Application Ref:	3/2021/0141	 Ribble Valley Borough Council www.ribblevalley.gov.uk	
Date Inspected:	24/03/2021		
Officer:	LE		
DELEGATED ITEM FILE REPORT:		Decision	Prior approval not required

Development Description:	Prior notification for proposed change of use of an agricultural building to 5 dwellings with operational development under class Q (a) and (b).
Site Address/Location:

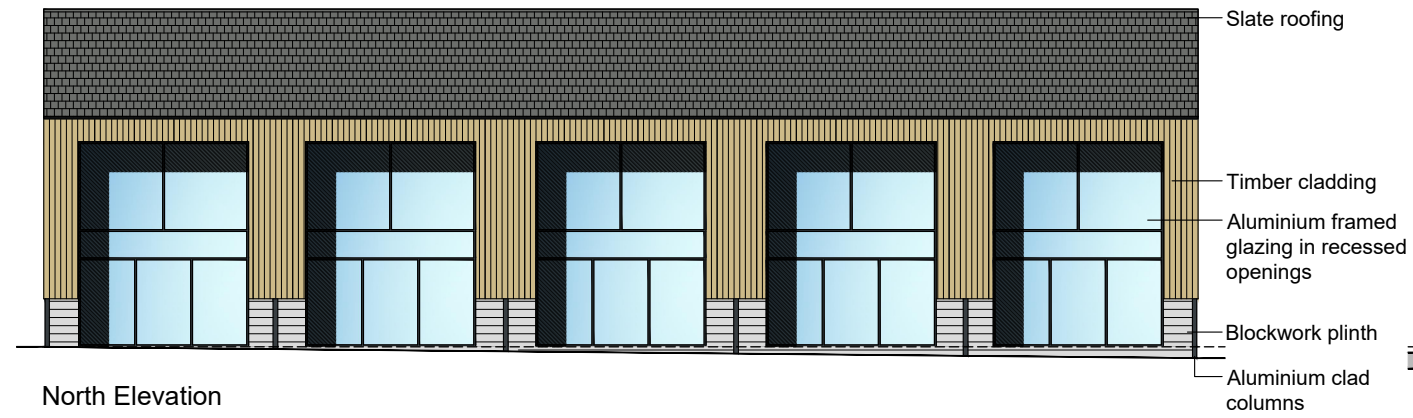
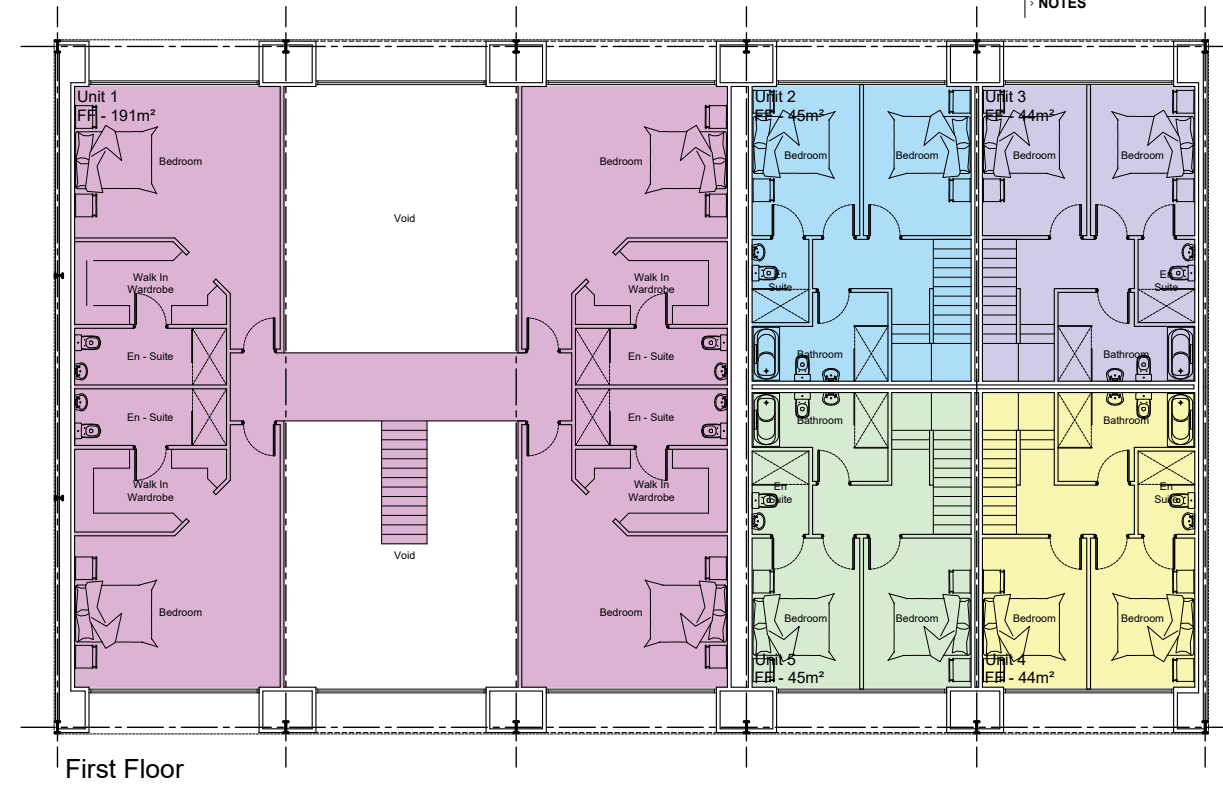
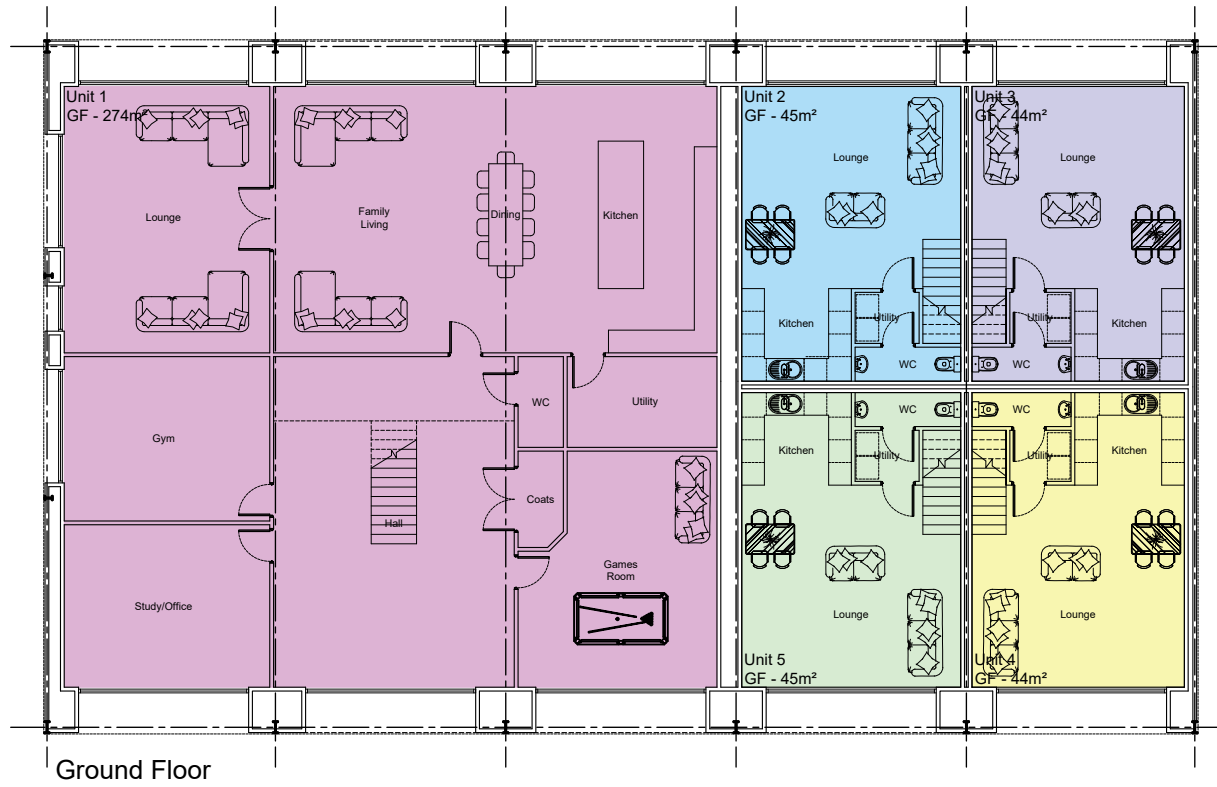
The resultant floor space of the larger dwellinghouse, having a use within use class C3, would amount to 465sqm (taking account of the annotated internal floorspace of the dwellings). However it is noted that the submitted floor plans appear to leave an unused void at upper floor level, either side of a corridor between the two bedroom areas. There does not appear to be and access into this area but it is not clear if the upper floors are mezzanines with part of the ground floor being double height or whether this void has a floor.

Taking this into account the proposal has not demonstrated beyond doubt that more than 465 square metres of floor space having a use falling within Class C3 (dwellinghouses) would be provided and the application therefore fails to comply with the requirements of Q1(h)

Taking into account the above, it is considered that the given the extent of building works based on the information before me, I consider that the proposal would go beyond what is ‘reasonably necessary’ to change the use of the building.

The building is a functional steel portal frames timber clad building rather than a traditional stone barn and other than the open end, does not have window openings. The proposal is to provide recessed full height glazing in aluminium frames, numerous significant openings and re cladding and roofing in a different material. The proposed alterations will significantly alter the appearance of the building and it is not considered that the rural character will be maintained. The design and external appearance is considered to be unacceptable.
